## Department of Transportation

June 11, 2019

re: Monument Academy Site Dev Plan - PPR199 - Walden YMCA

WALKER ROAD PLAN & PROFILE

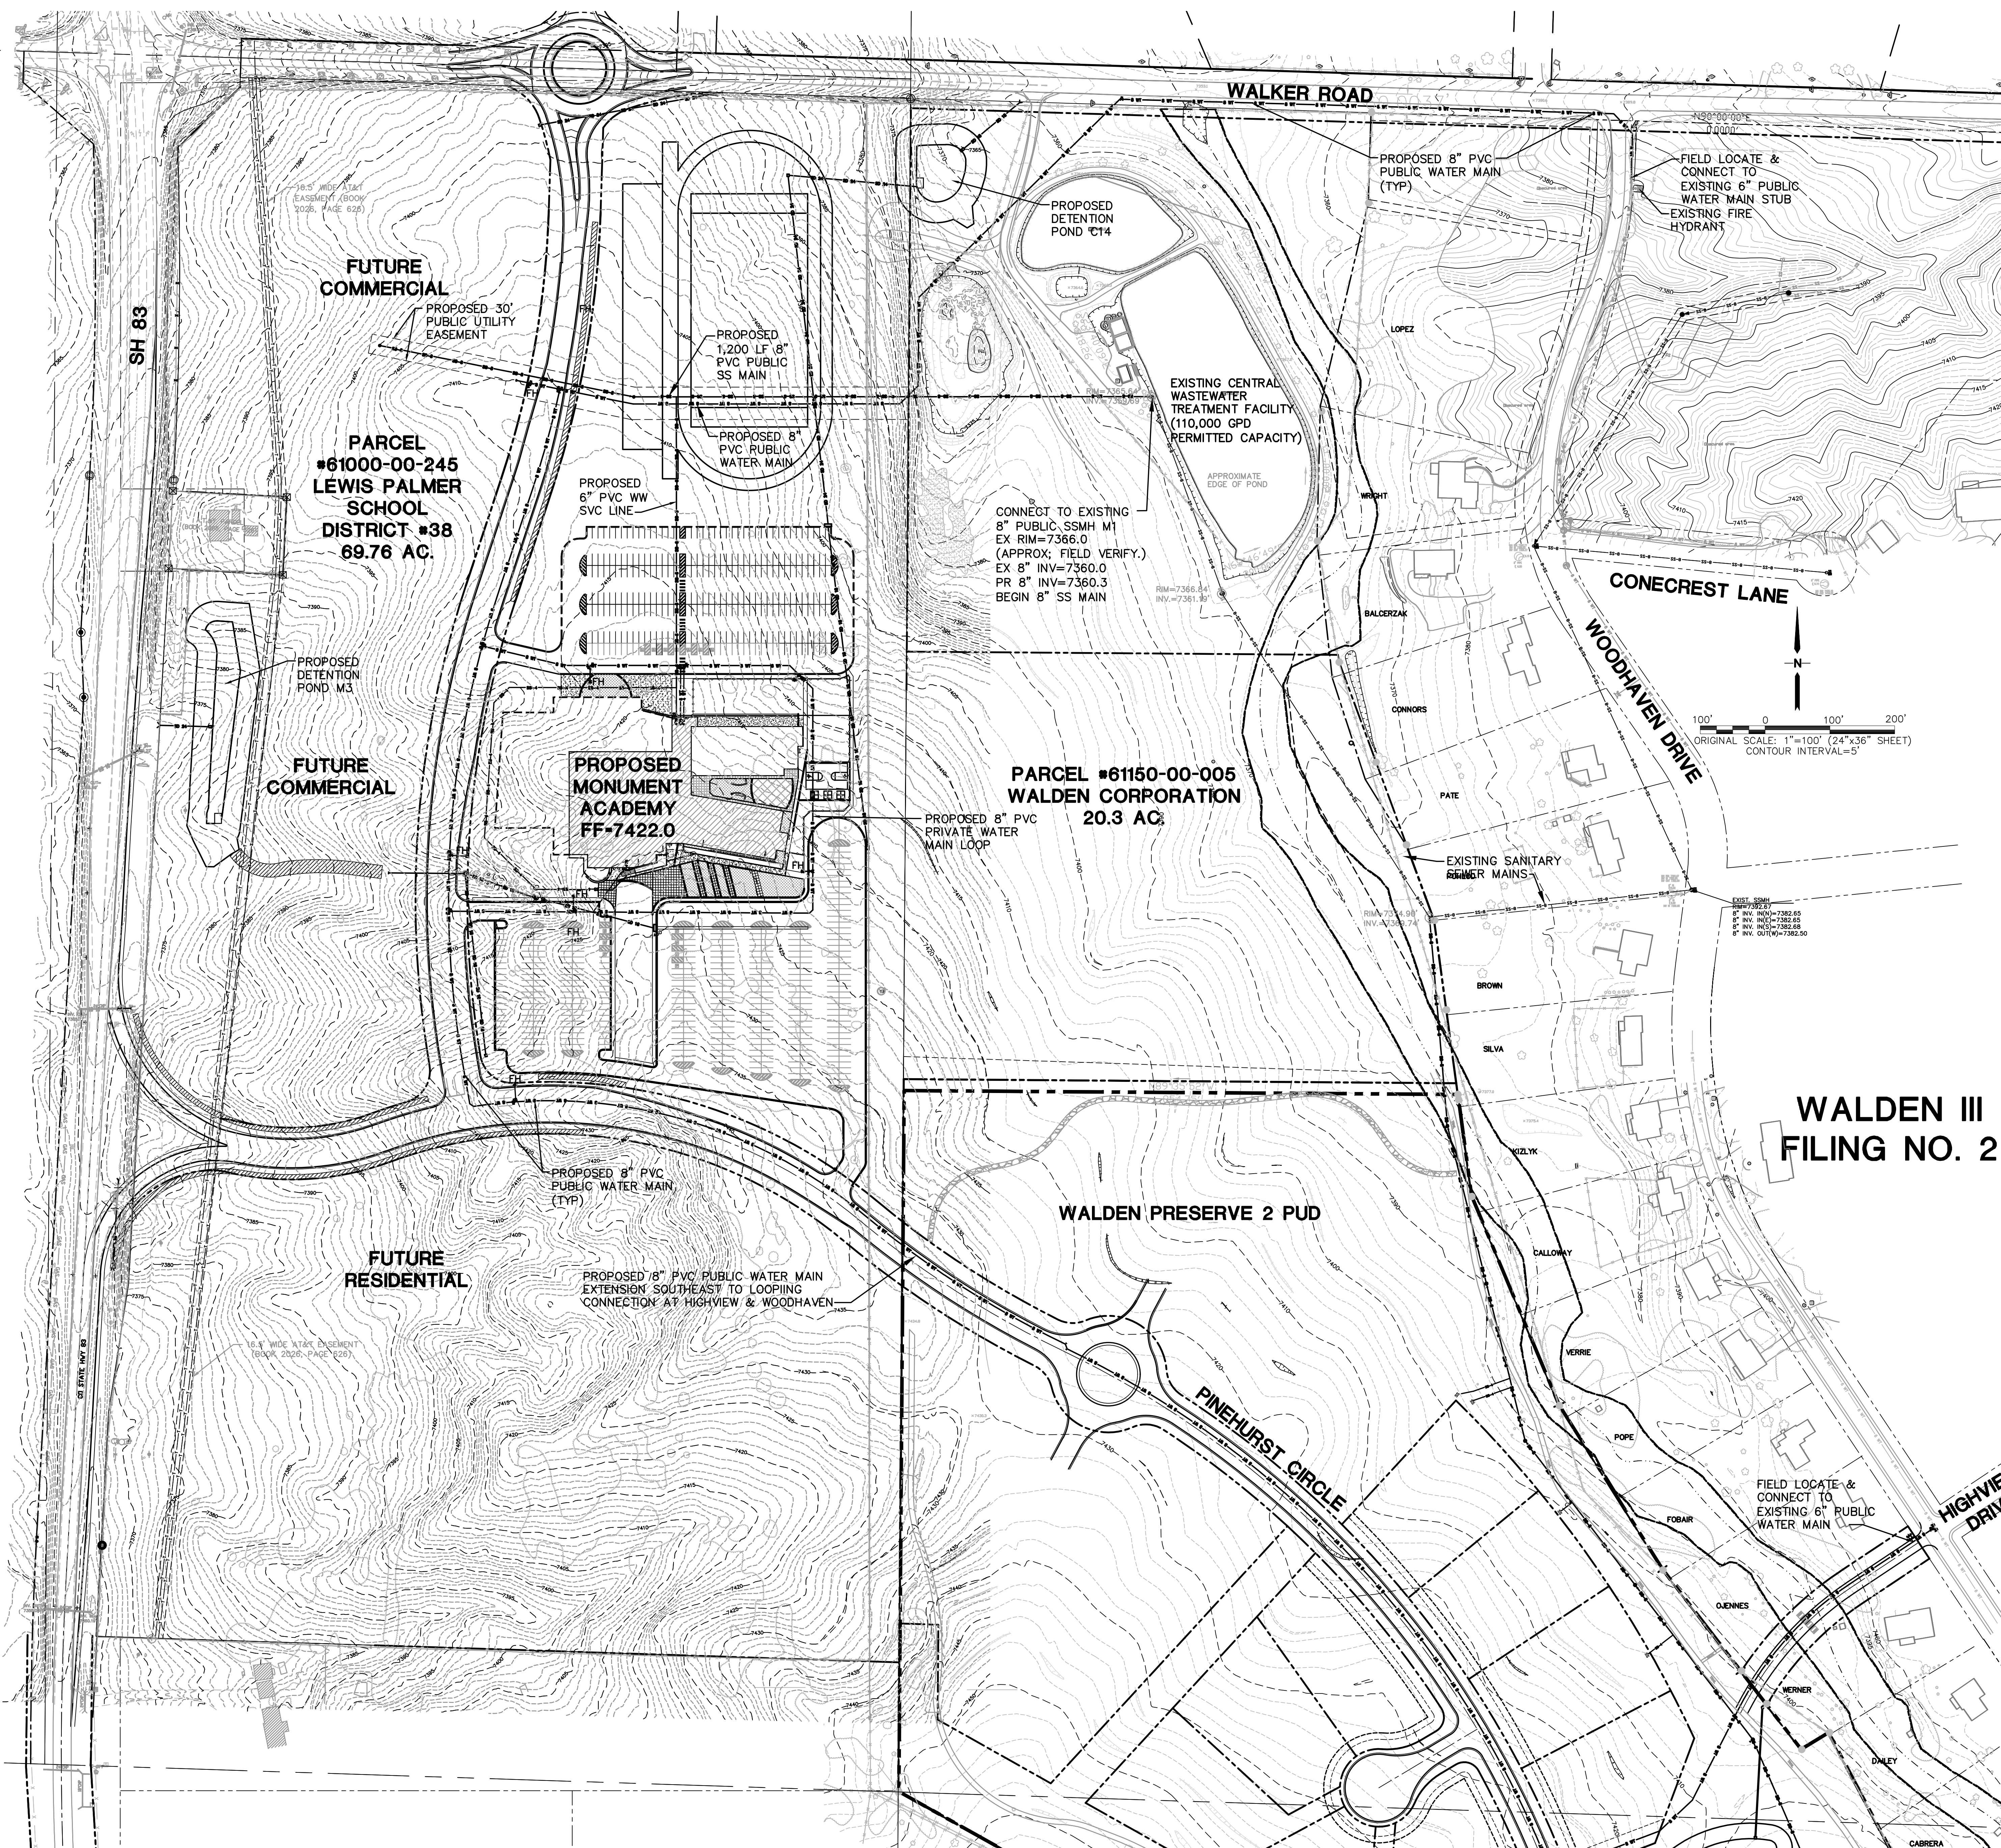
- i. **Walker Rd/Road A connection:** Request for access is being proposed to make connection to Walker Rd., an EPC controlled roadway. The site plan shows connection to Walker Rd. via a newly proposed roadway, "Road A" with a roundabout circle. Conversations with the Developer and EPC also mention a "T" intersection or signal controlled intersection as stated in other versions of the TIS submittals.

- j. Special consideration will need to be taken in the design of the Walker Rd. and Road A intersection for the allowance of the re-alignment of Shannon Rd.

- k. CDOT requests EPC to require the installation of a roundabout as originally proposed in the site plan. The roundabout option would presumably be the best option and further study is needed.

ENLARGED DETENTION POND M3 PLAN

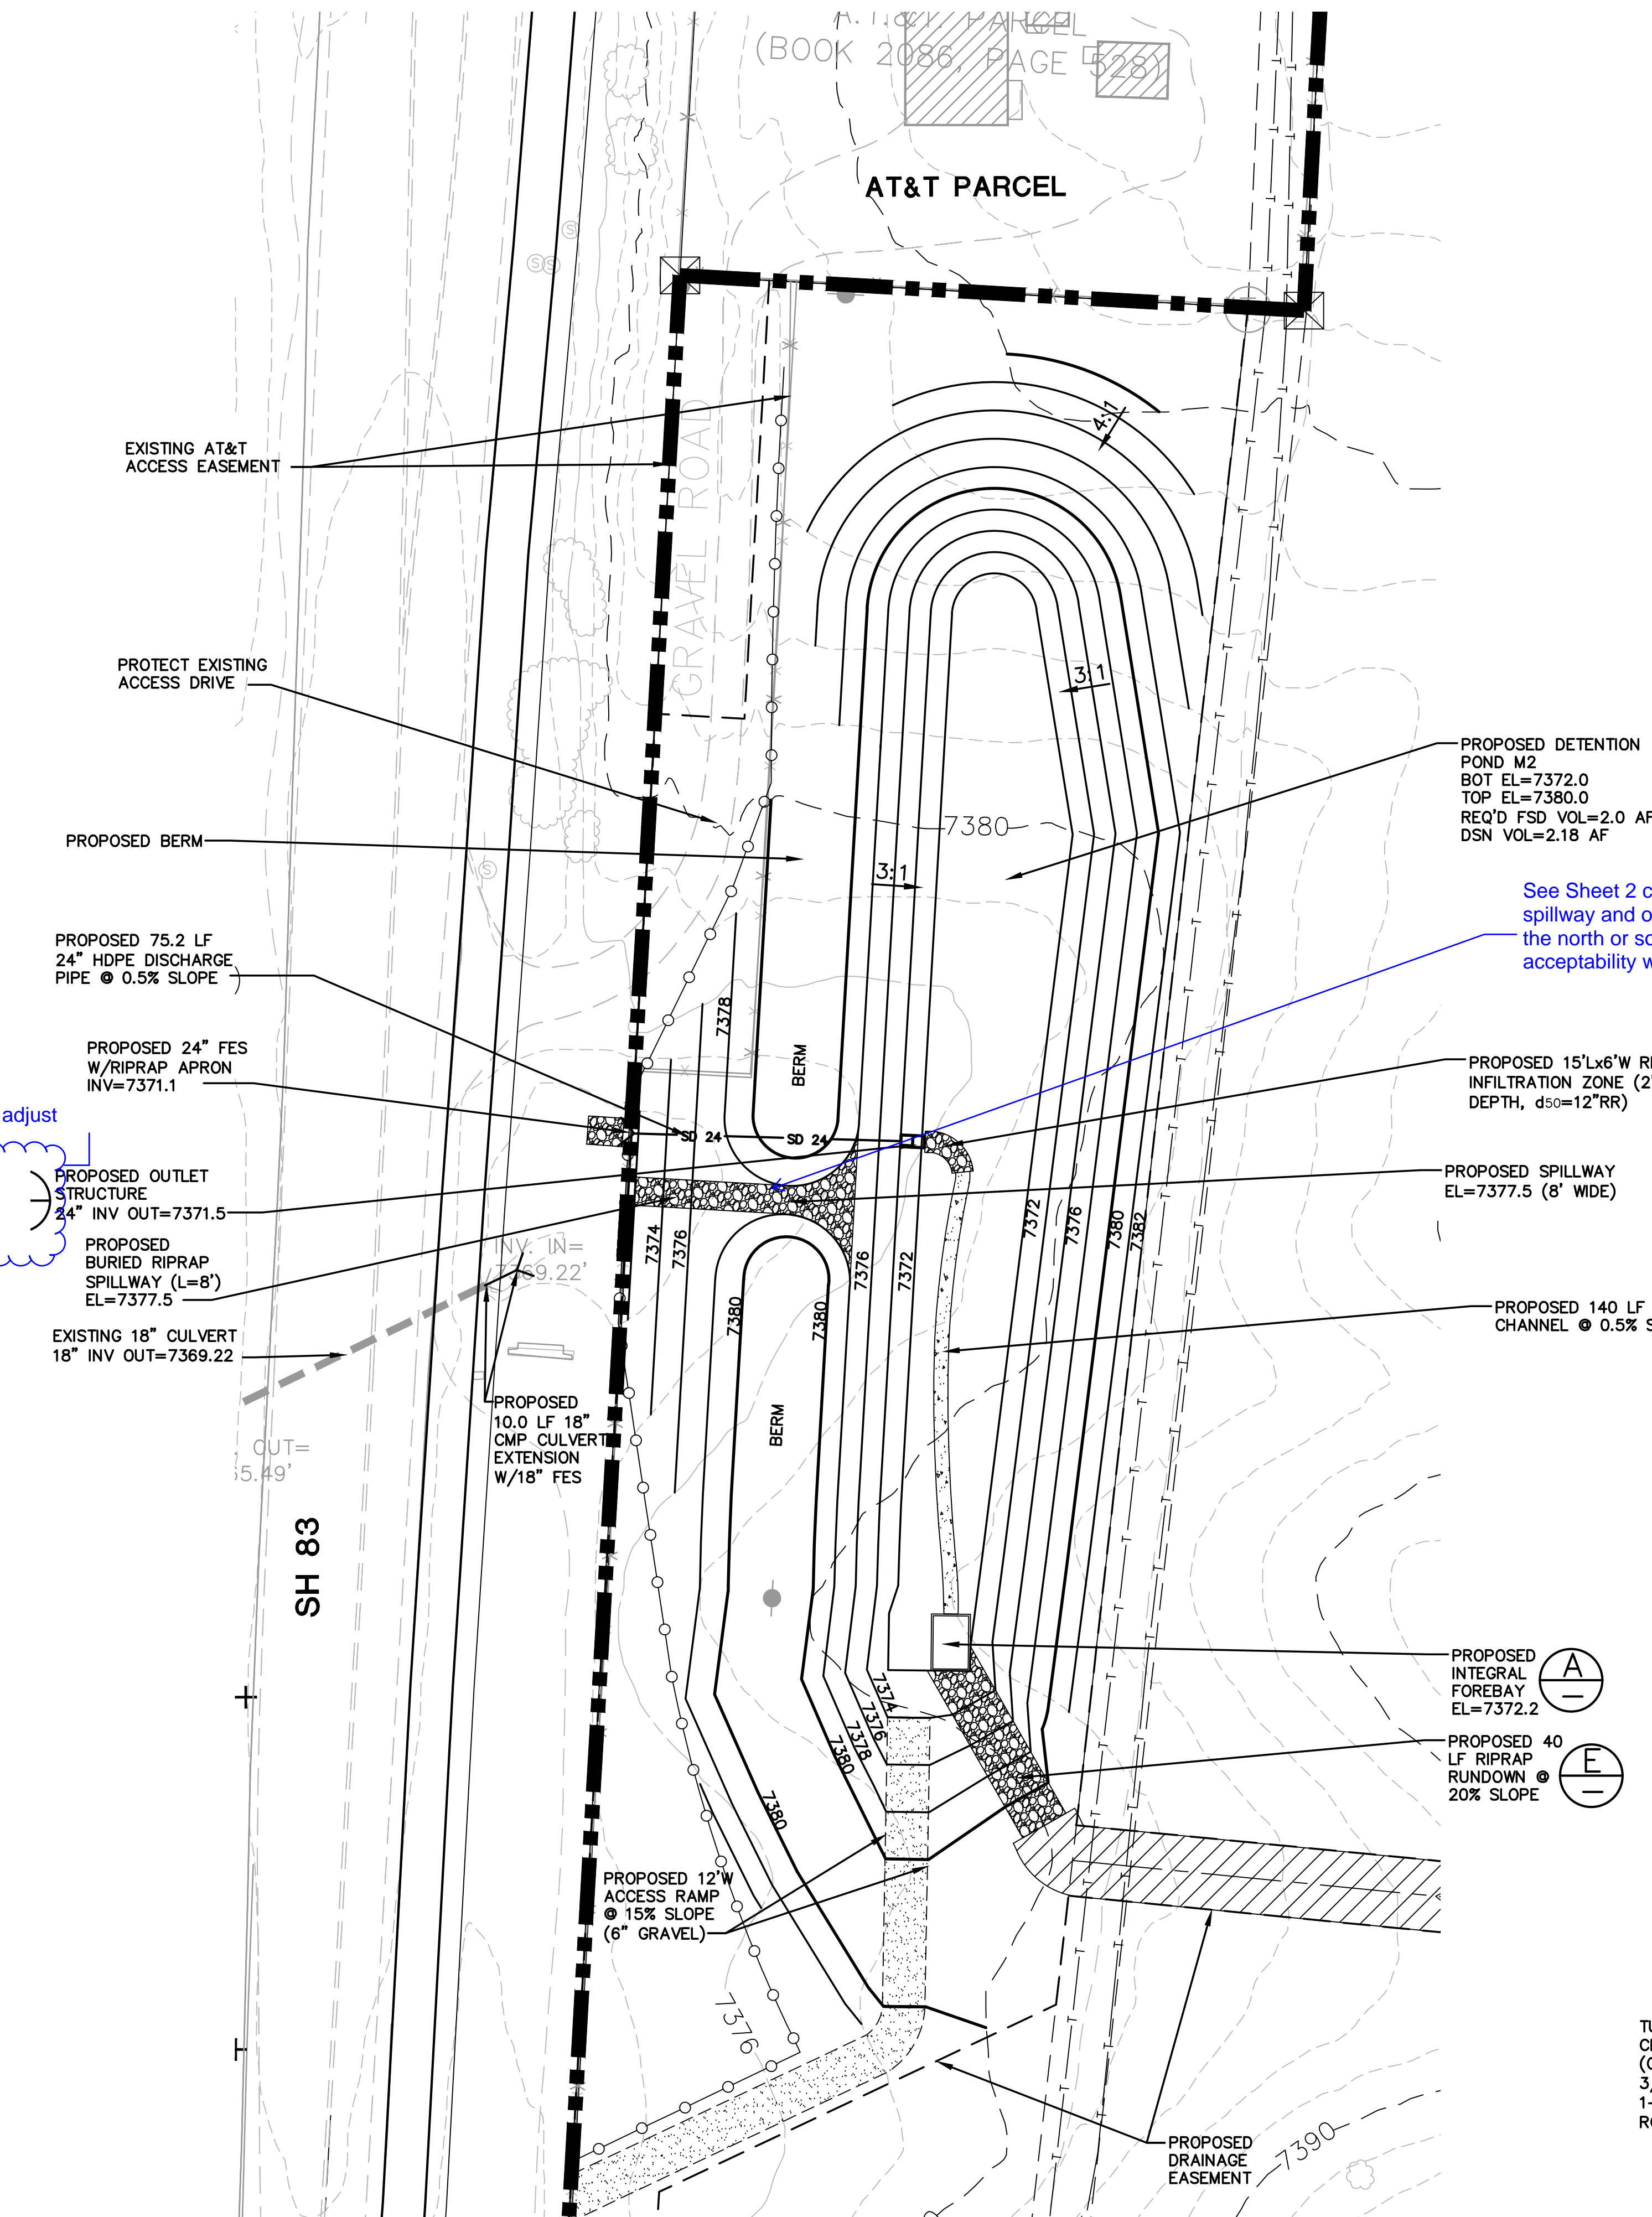
- b. Drainage Report/Grading Plan, Pond M3 - Pond spillway elevation given on pond sheet, but grading does not reflect spillway. At the height show, this pond exceeds 10' in height and could be classified as a jurisdictional dam. Please show grading of spillway to avoid this. Also, please provide detail of spillway and material used. Use of UDFCD spillway design guidance recommended.

- c. Drainage Report, understanding that Pond M3 is designed to discharge at historic rates, please confirm the culvert crossing US 83 is sized properly to handle flows from the pond outlet along with the additional flows from the roadside ditches.

- d. Drainage Report, Forebay size required = .011 ac-ft., size provided in UD-BMP spreadsheet = 0.005, reviewer calculated = .007. Please increase forebay size to meet minimum required.
